Addendum No. 2

RE: Contract # C204741

Cabarrus County (B-5808)

BRIDGES #57 AND #59 OVER IRISH BUFFALO CREEK ON US-29 AND US-601.

DETAIL 'C' #4K44 BARS NOT SHOWN FOR CLARITY.

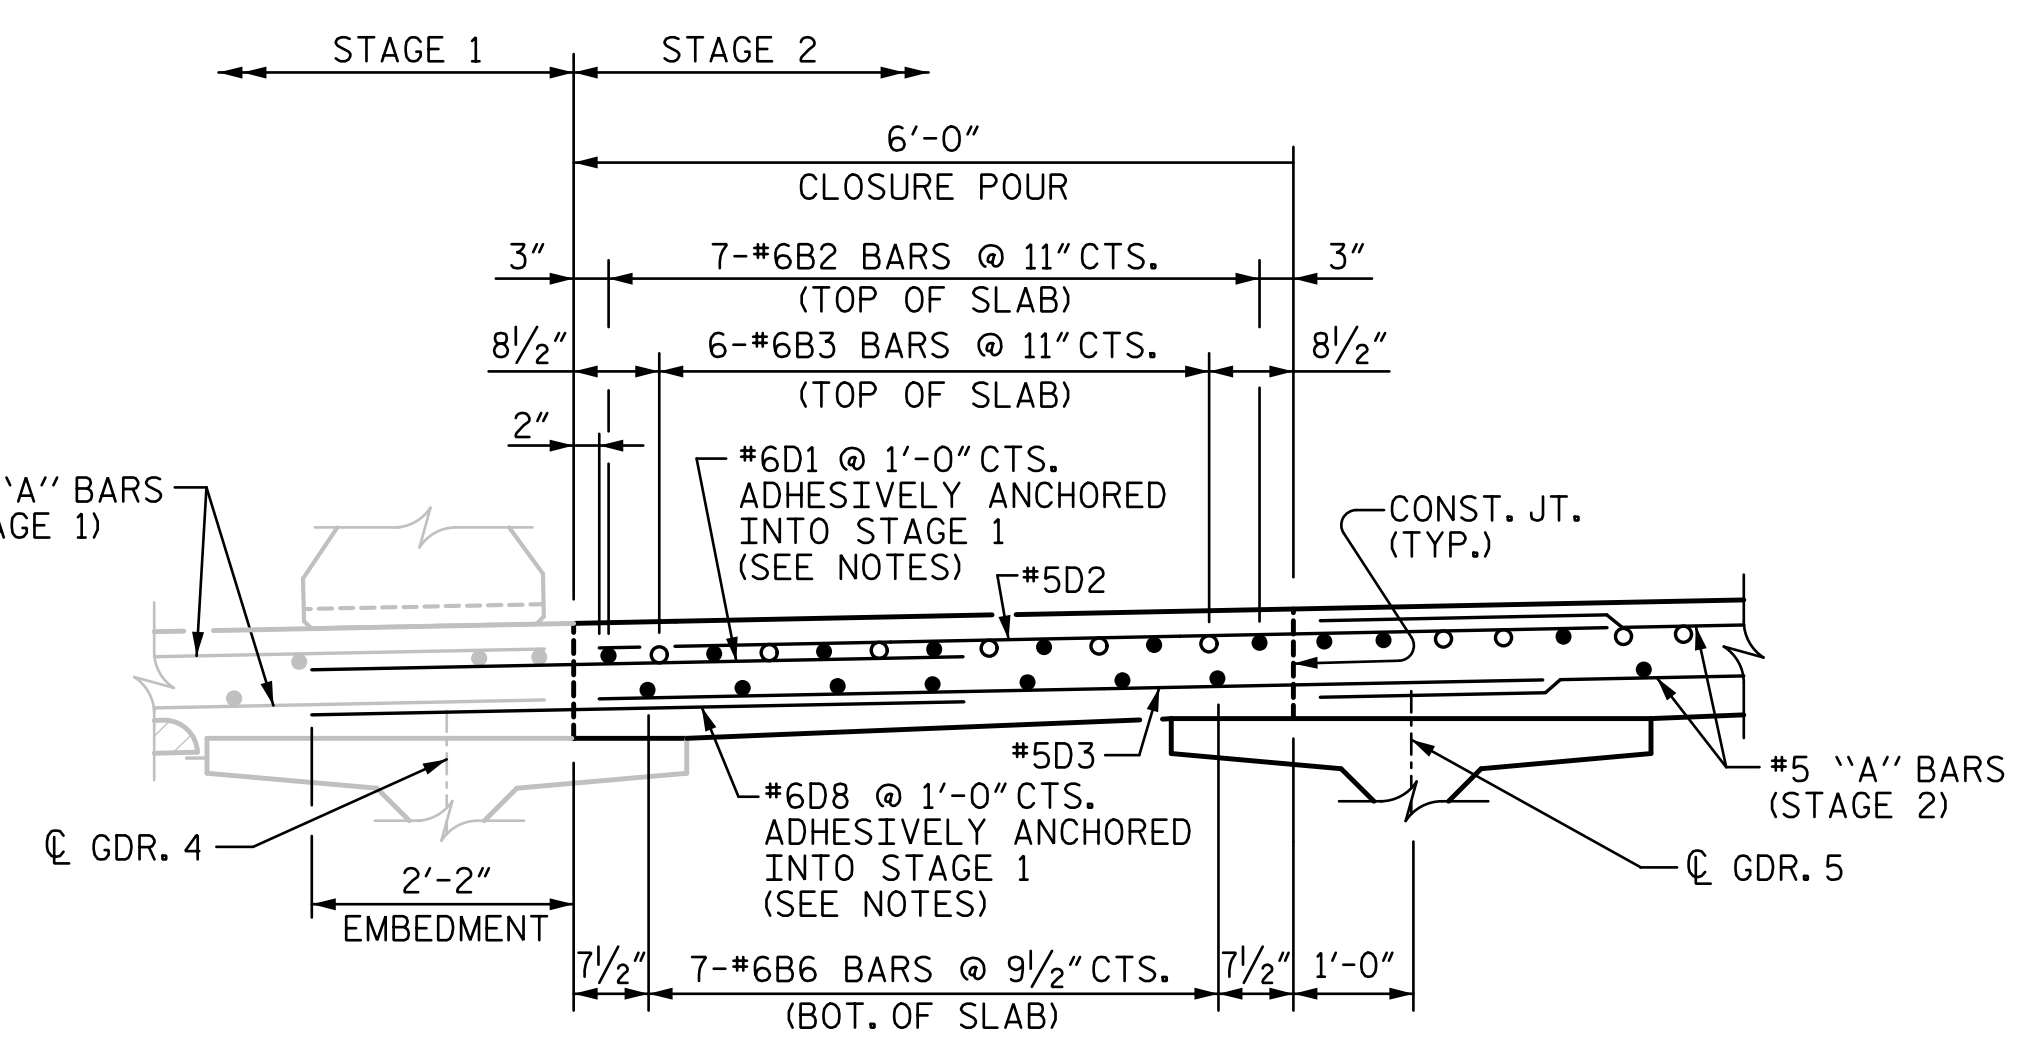
Sheet No.	Revision
S-6 thru S-8	Note regarding Temporary Barrier added.
S-9	Temporary Barrier w/Drainage Slots note revised.
S-25	Twelfth Paragraph removed under "Notes".
